ENG-SF19014-R4-MDDP-Redlines.pdf Markup Summary

ENG-SF19014-R4-CD-Redlines.pdf Markup Summary

ENG-SF19014-R4-GEC-Redlines.pdf Markup Summary

CROSS PAN & CURB
RETURN PROFILES

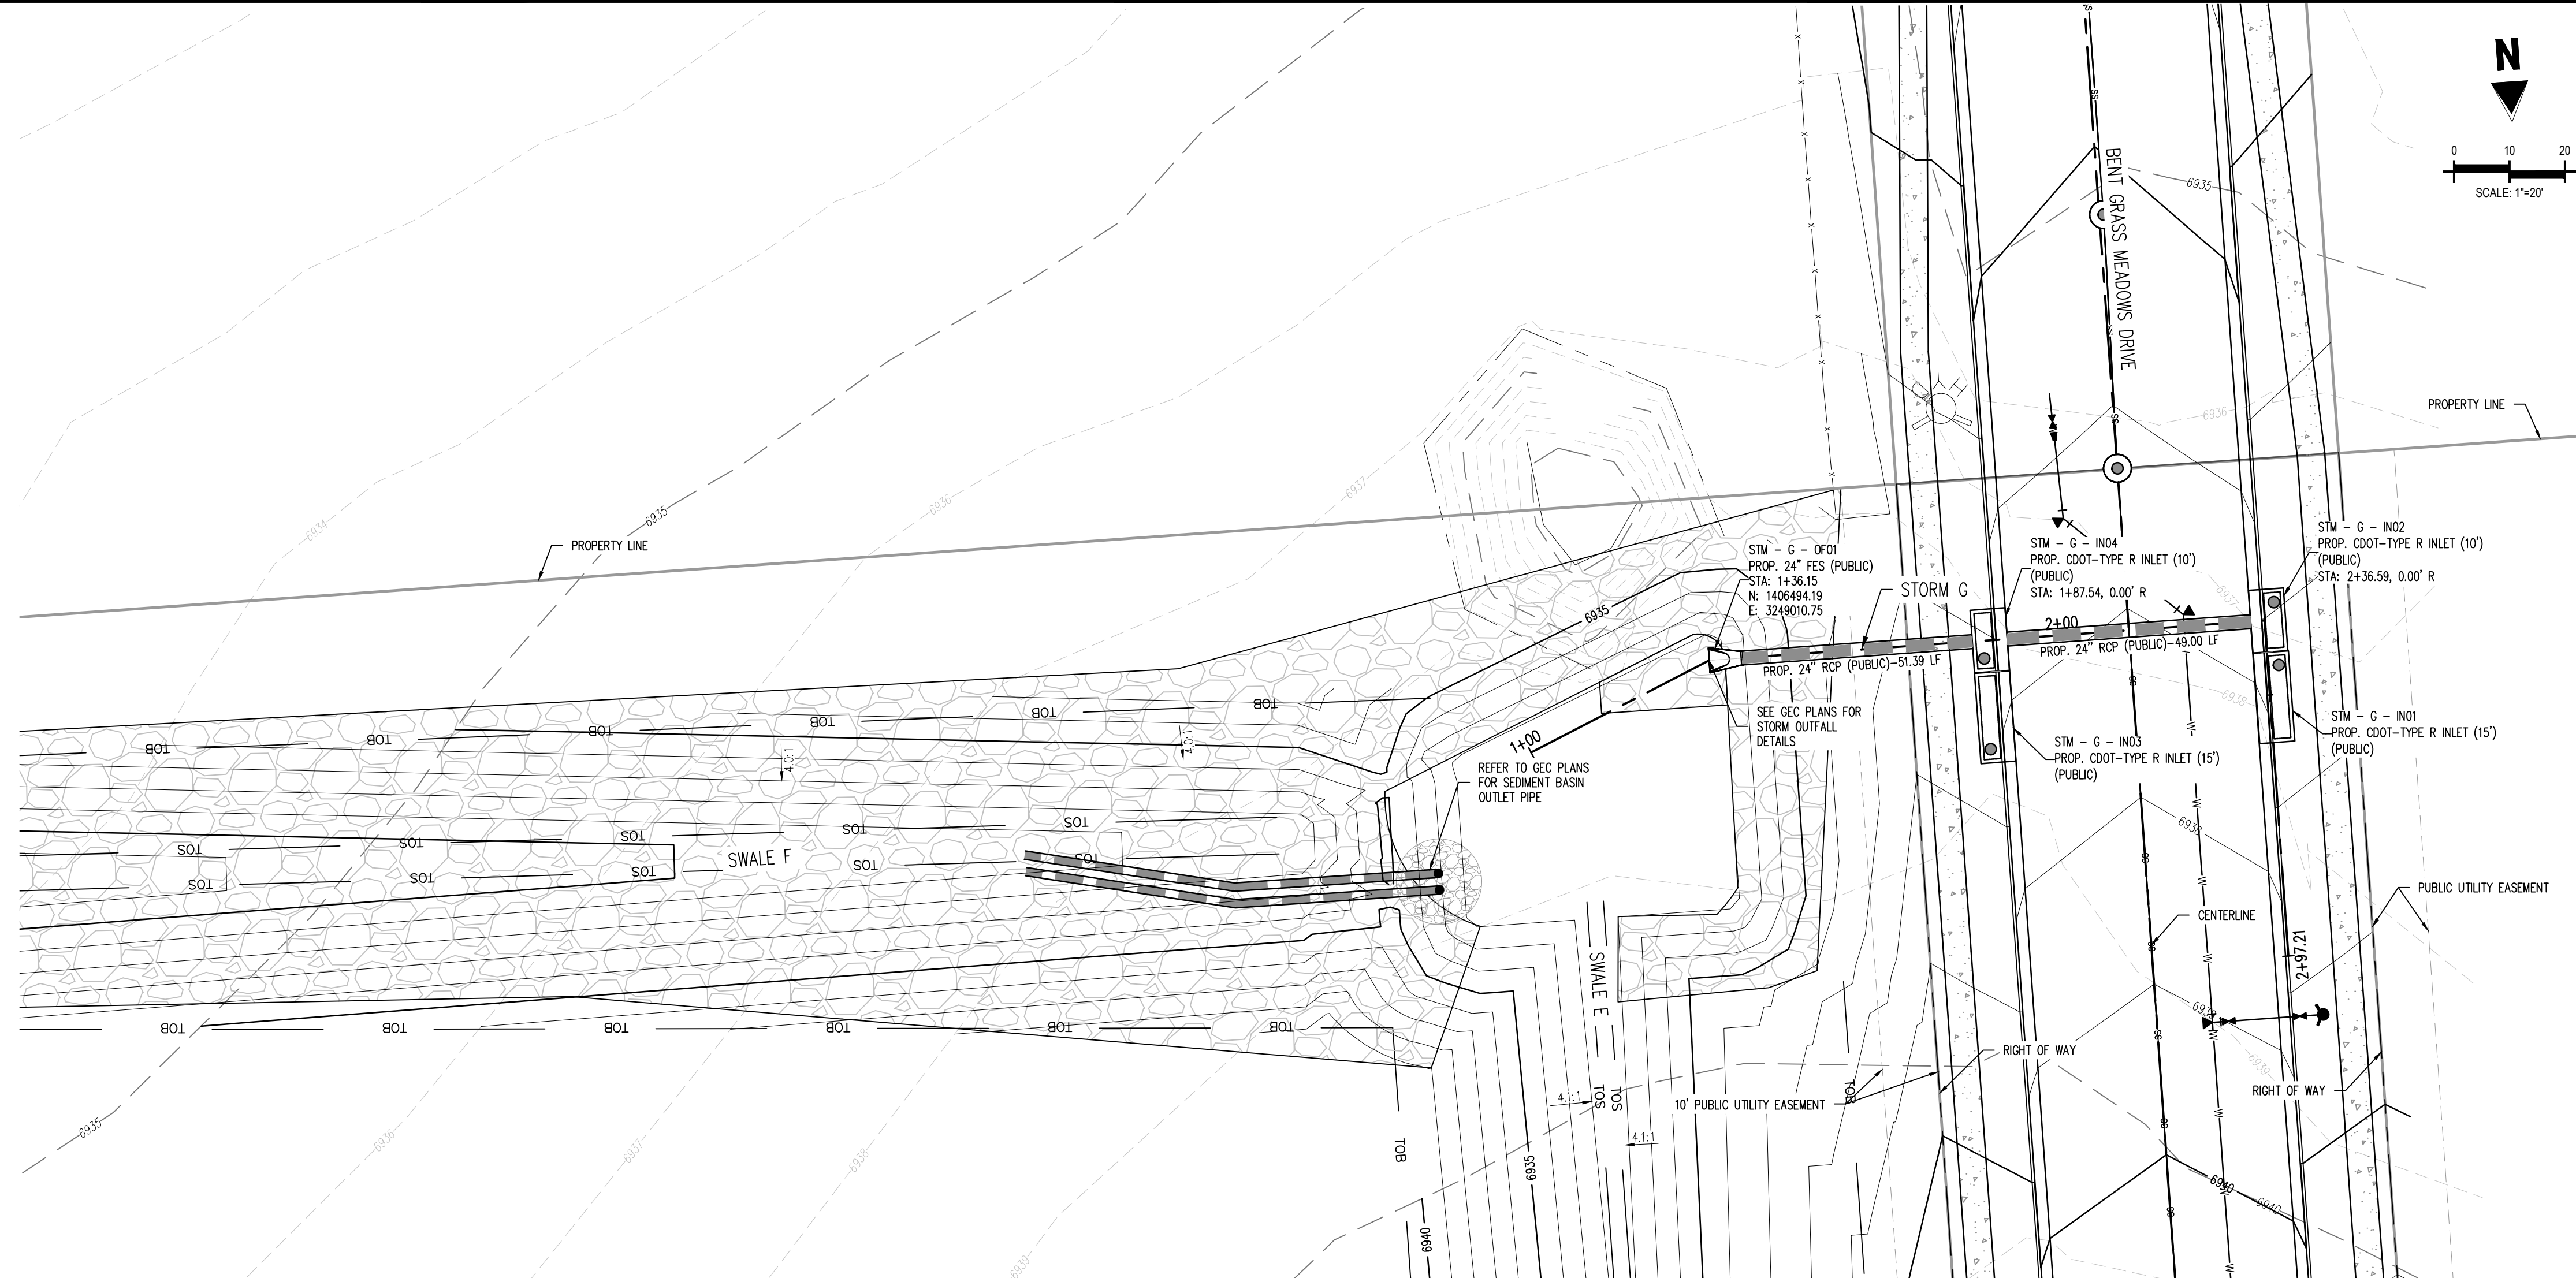
Provide a low point matching the crosspan

Project No: CLH000014.20
Drawn By: JDP
Checked By: RGD
Date: 4/17/2020
BENT GRASS MEADOWS
DRIVE STORM PLAN &
PROFILE

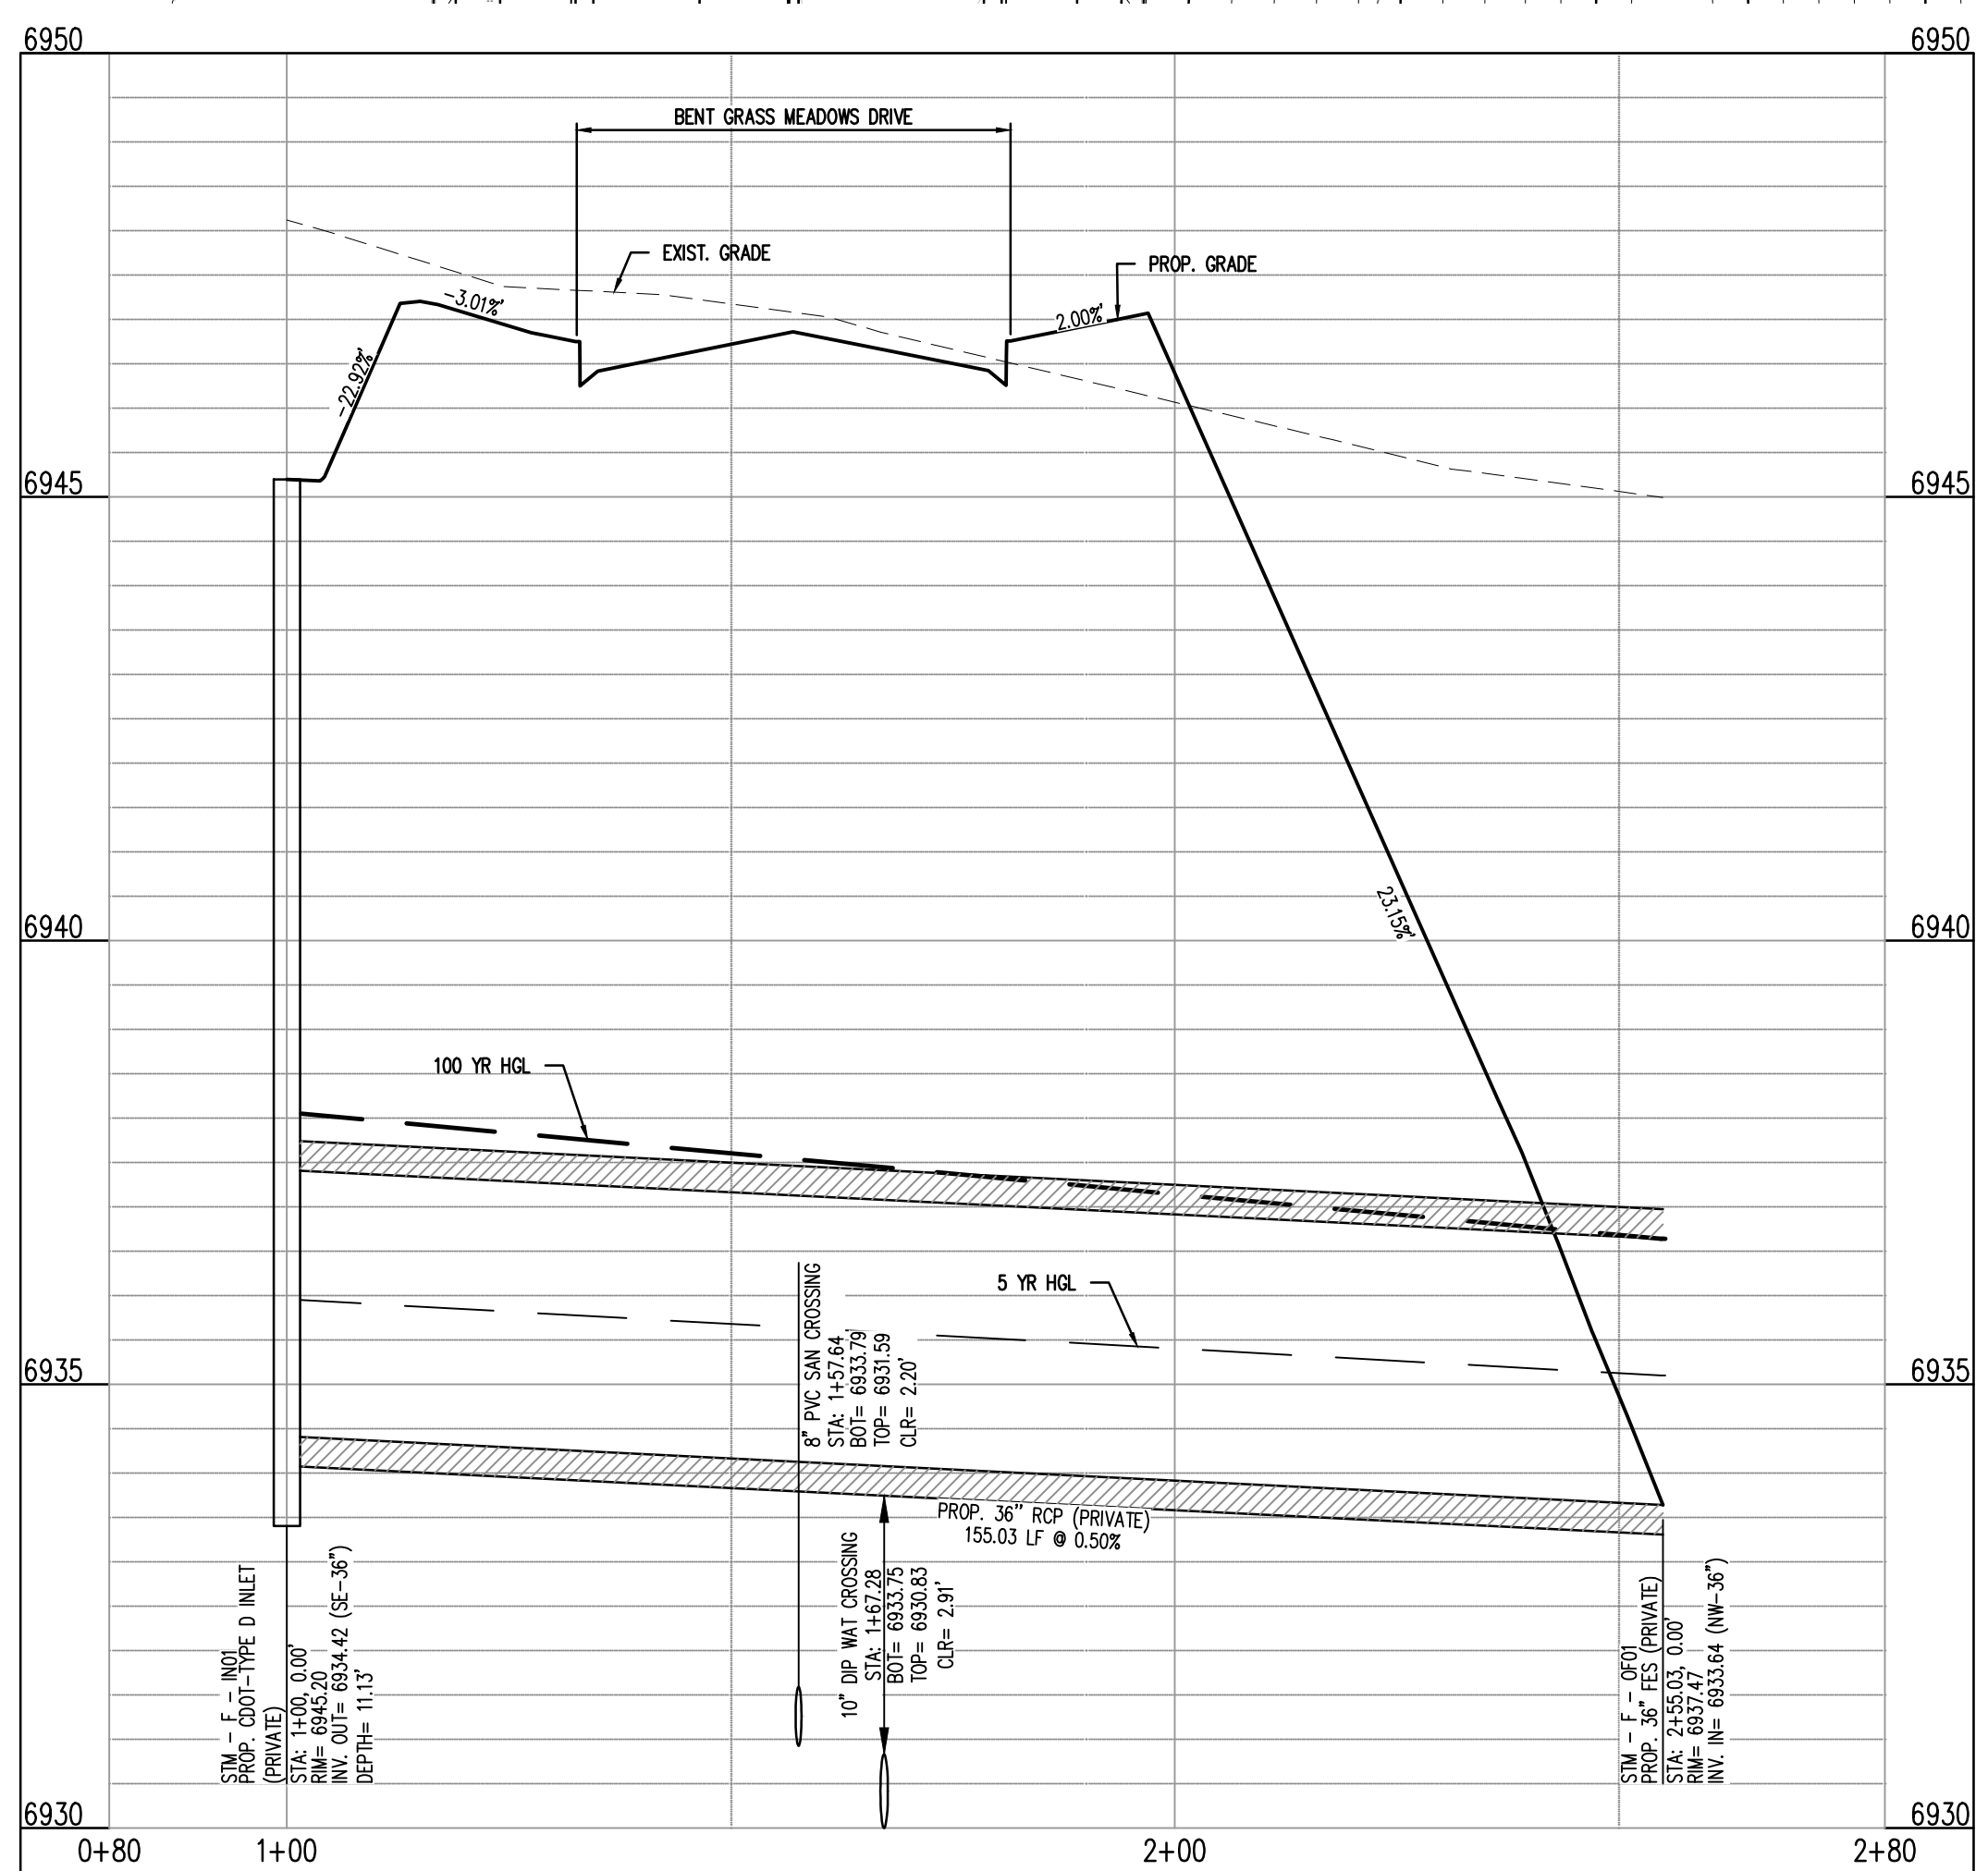
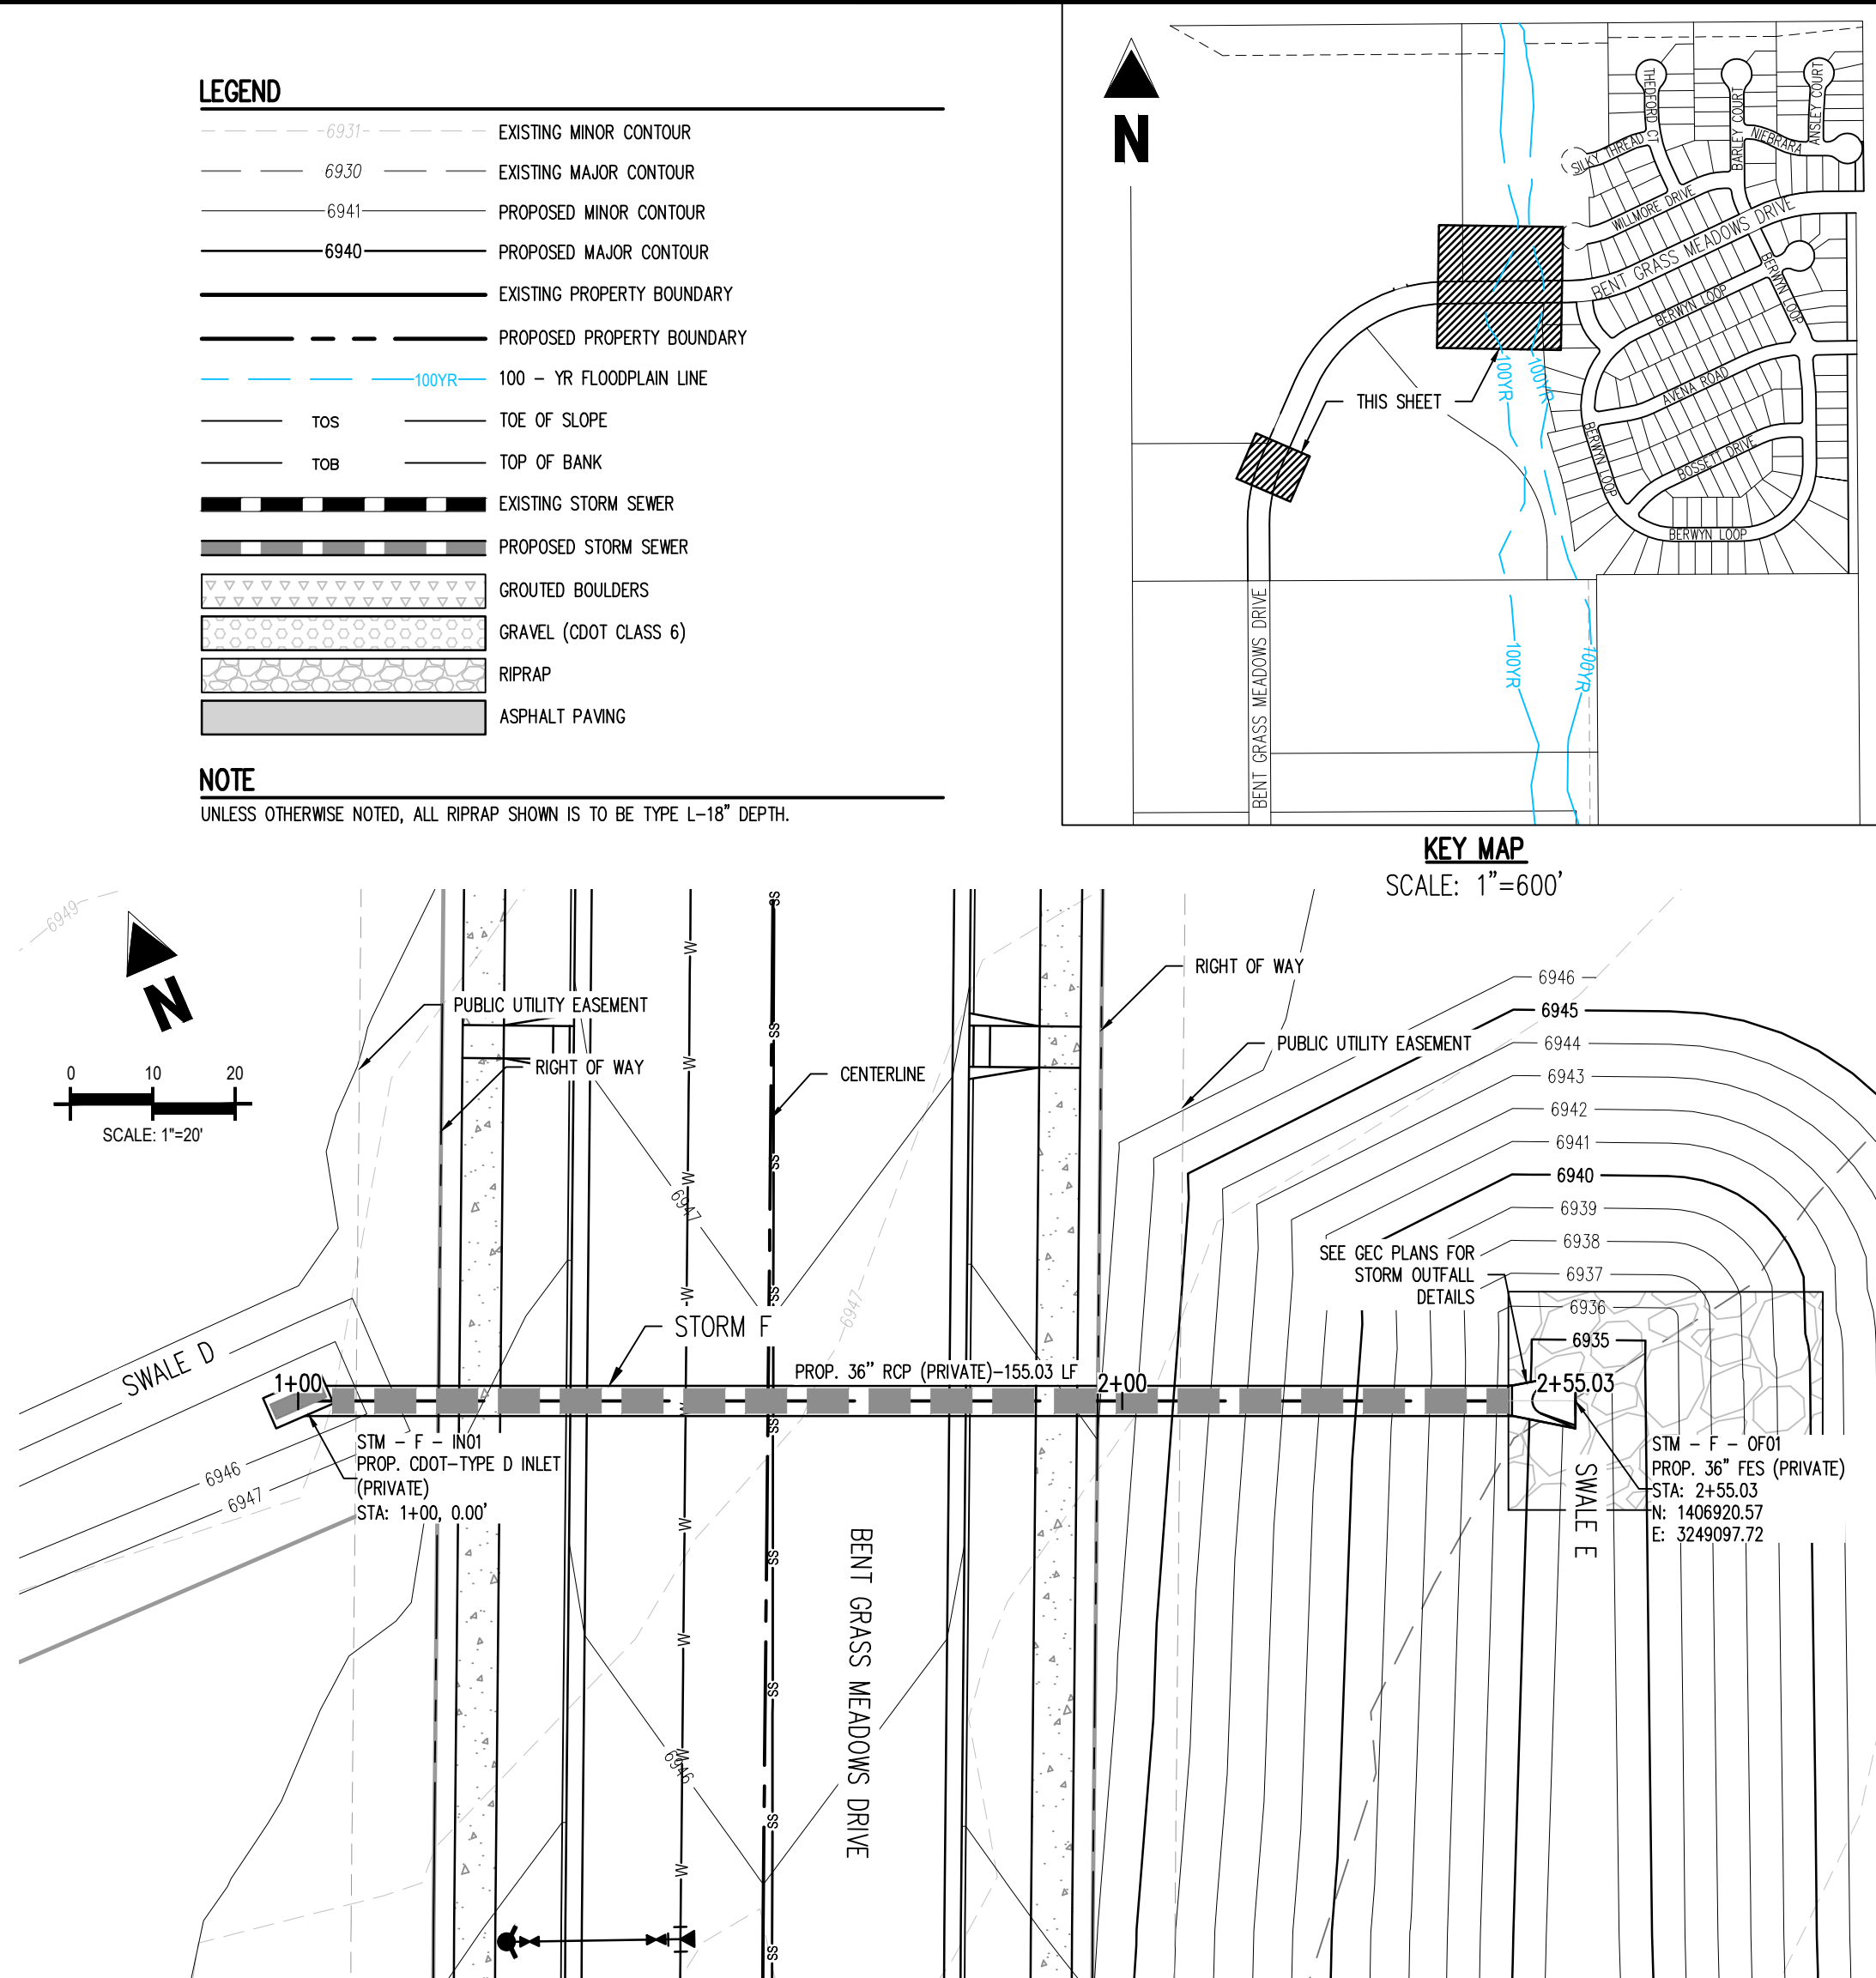
TYPE C INLET
(PUBLIC)
-03.86, 0.01' L
